A47 Blofield to North Burlingham

Scheme Number: TR010040

8.13 Statement of Common Ground with Highways England and Blofield Parish Council

Statement of Common Ground – Blofield Parish Council

SUITABLE FOR INFORMATION

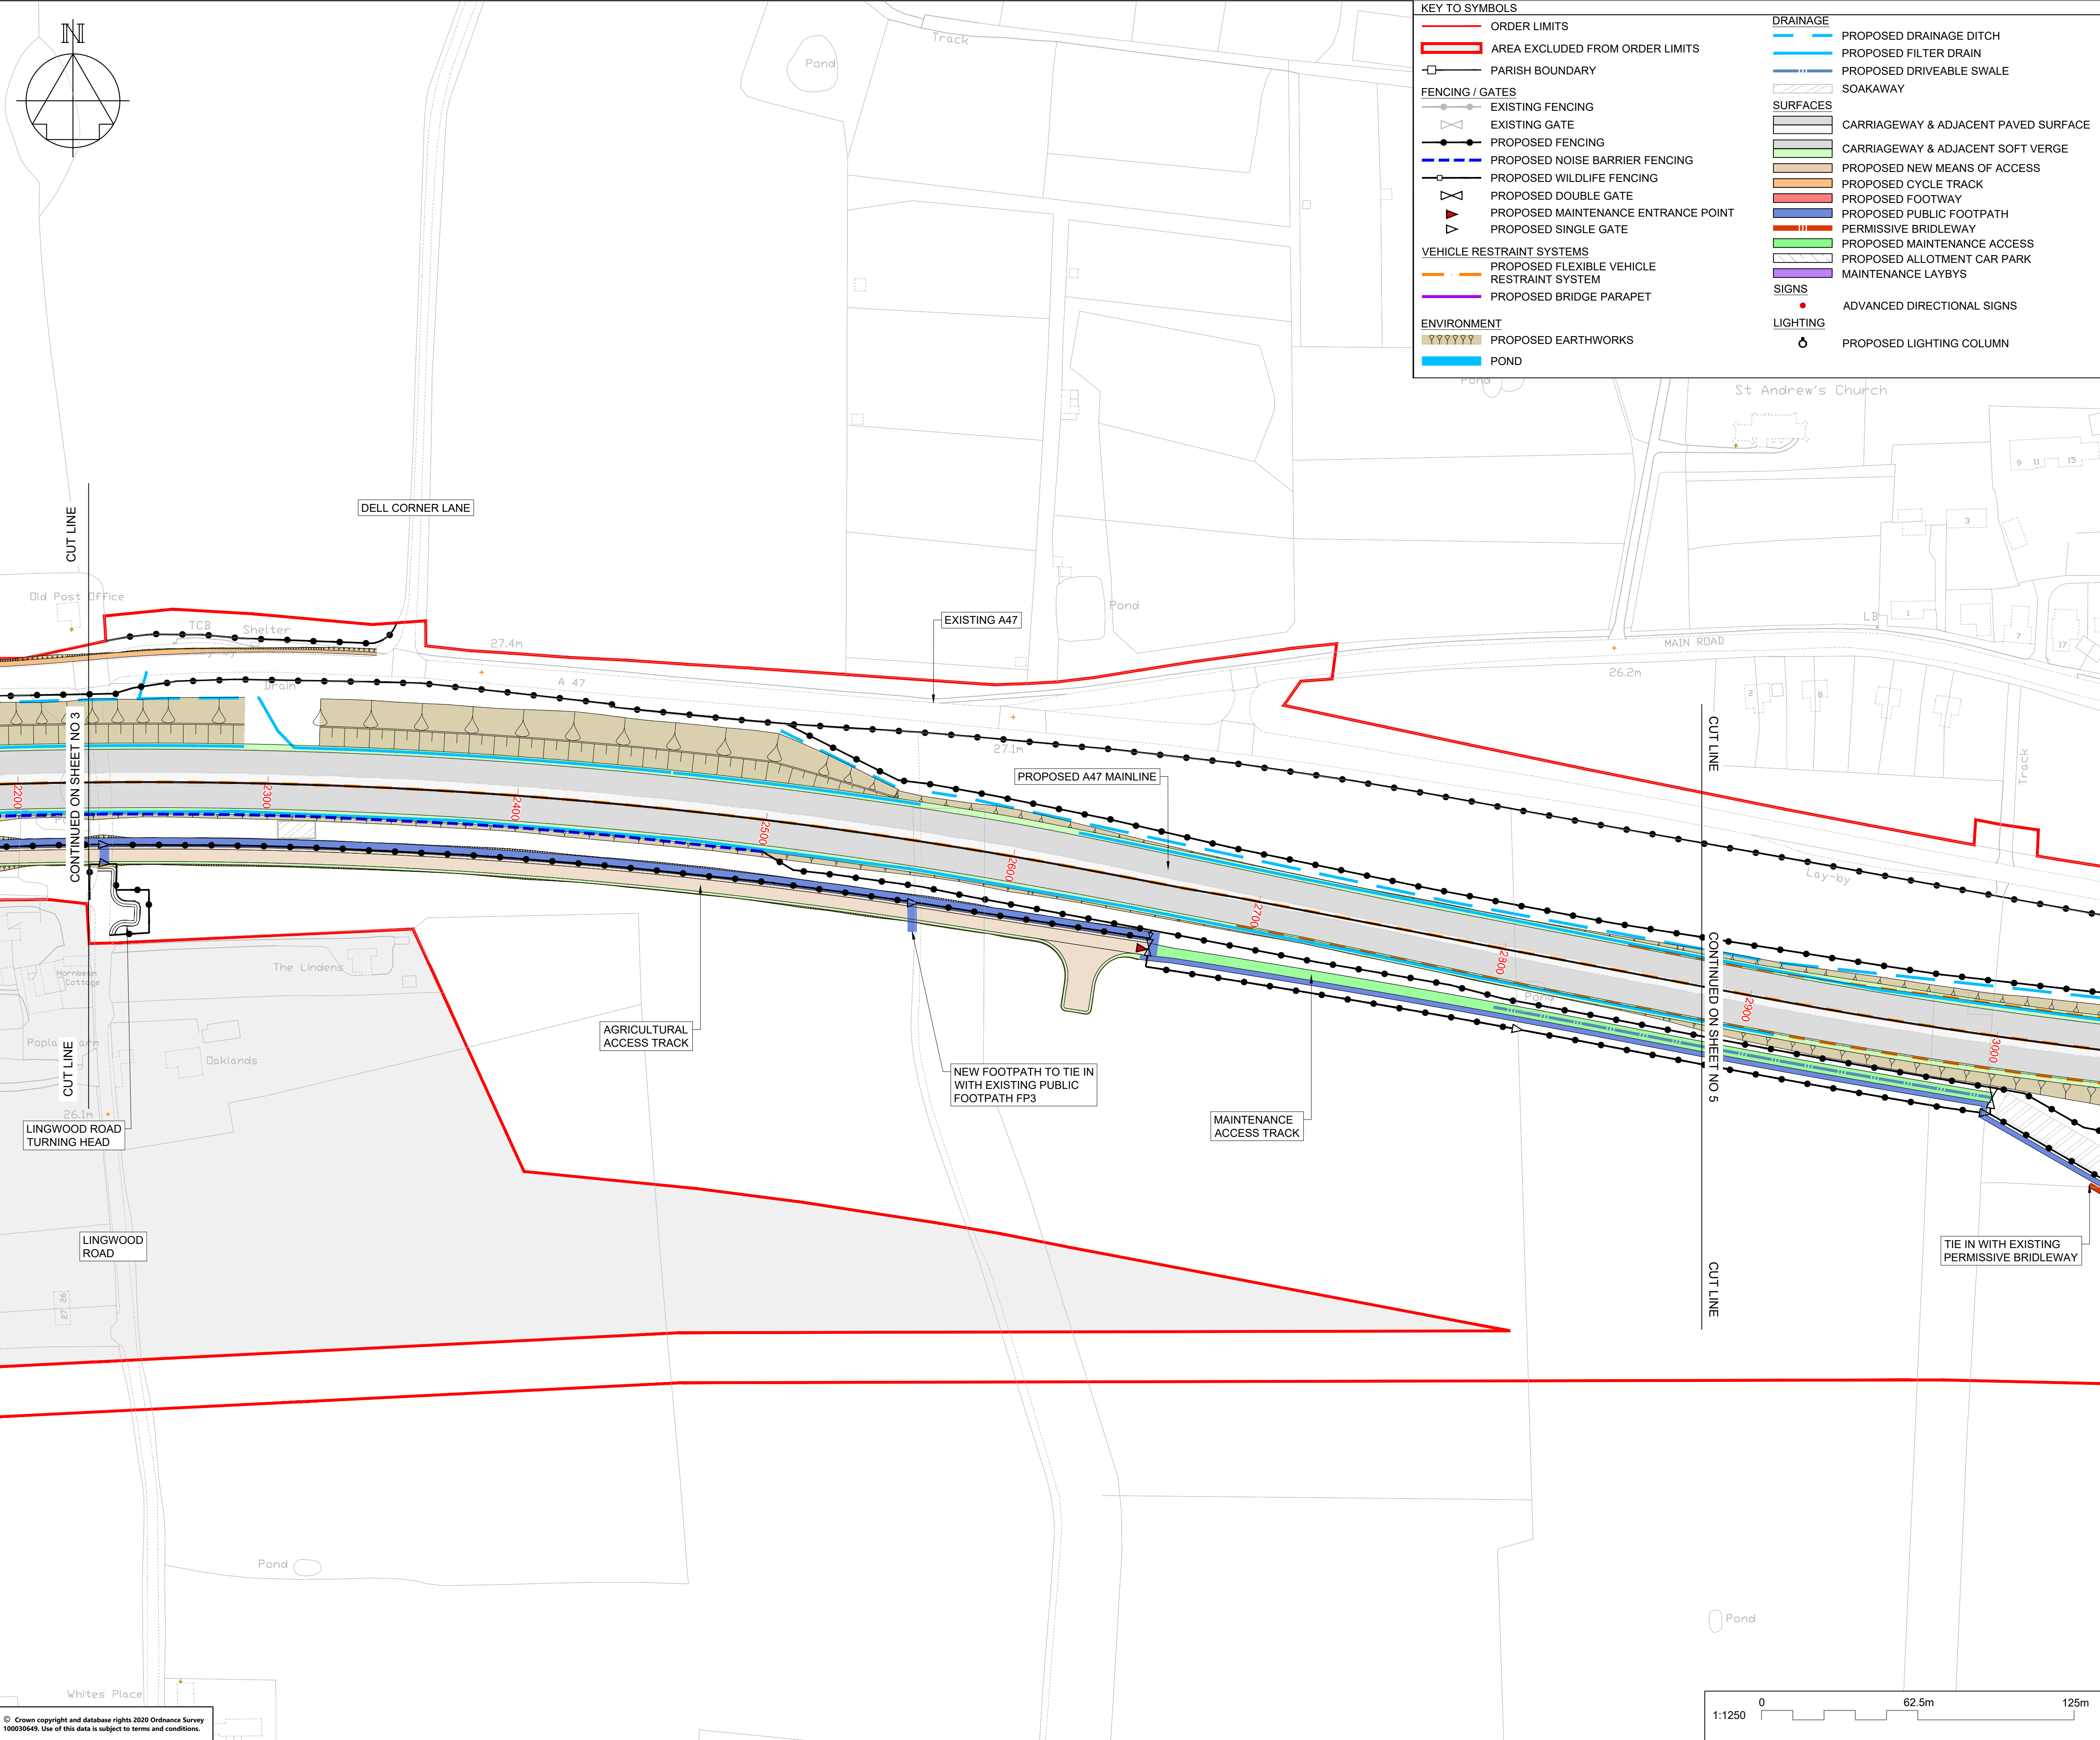
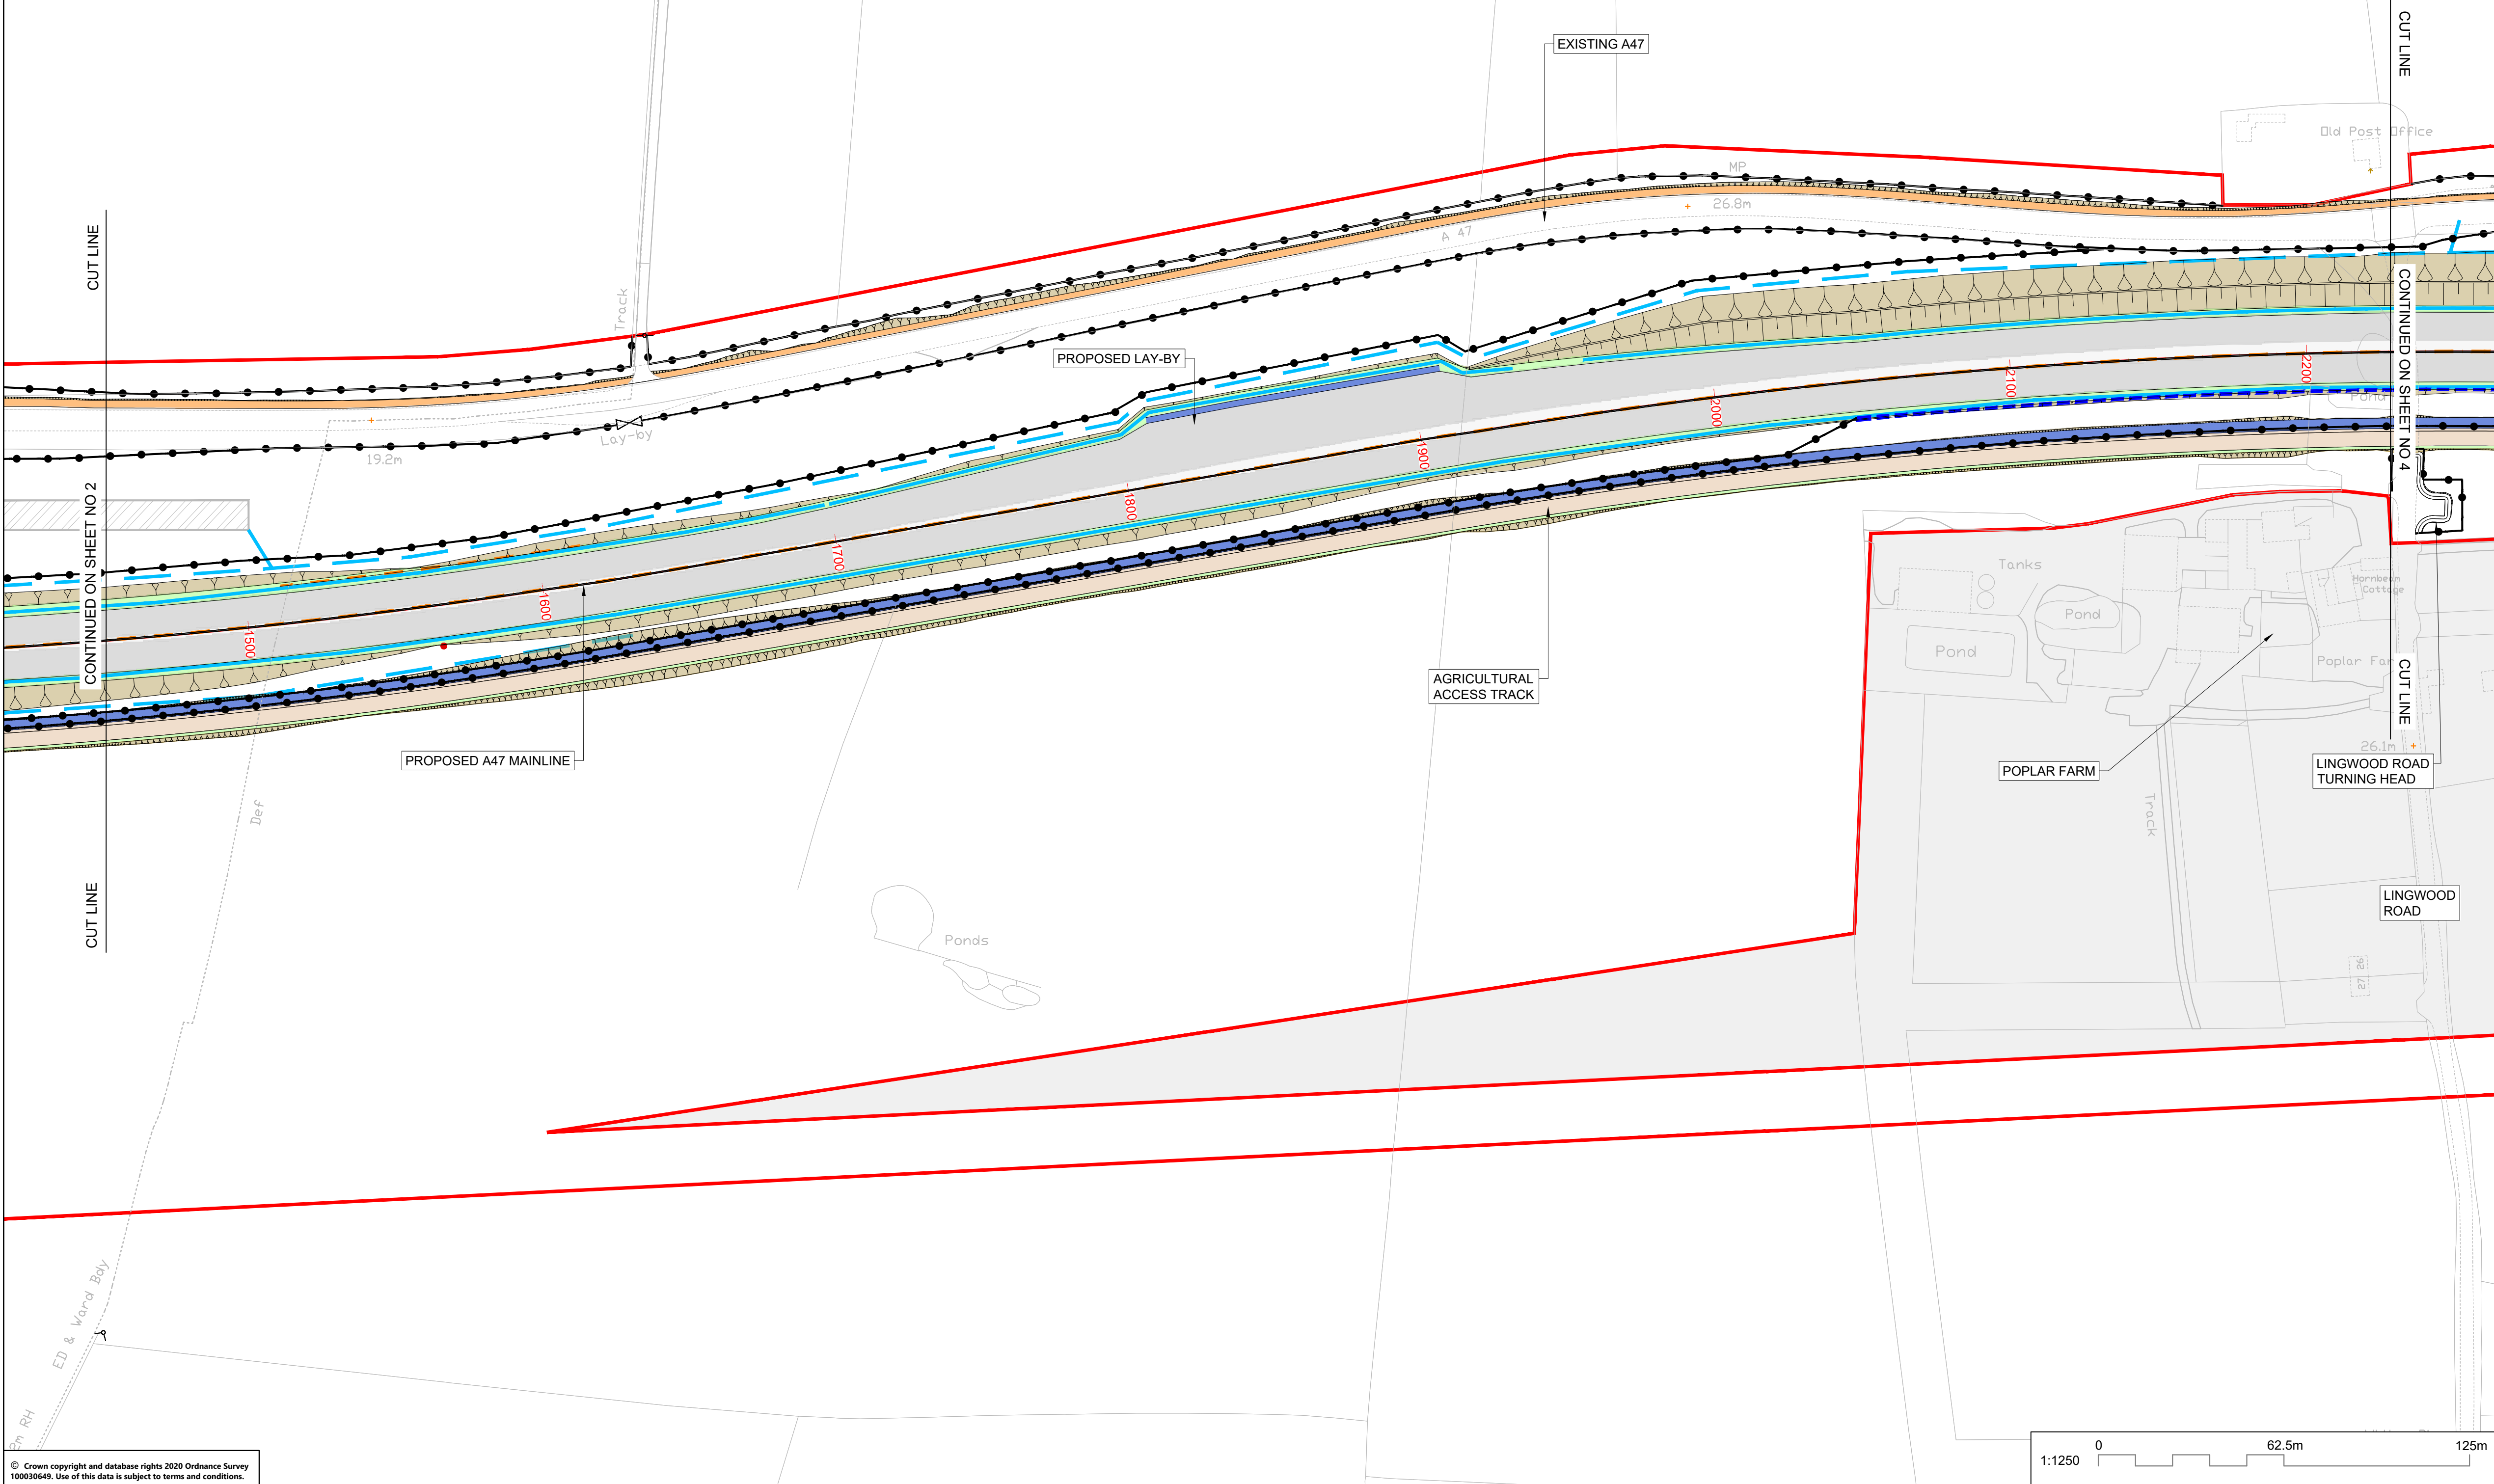
Road Lighting	Letter from BPC in Appendix C	2.6 General Arrangement Plans The proposed 20 lighting columns would be in contradiction of the Blofield Neighbourhood Plan	As described in the Scheme Design Report (APP-122) lighting is proposed at the Yarmouth Road as road safety mitigation.
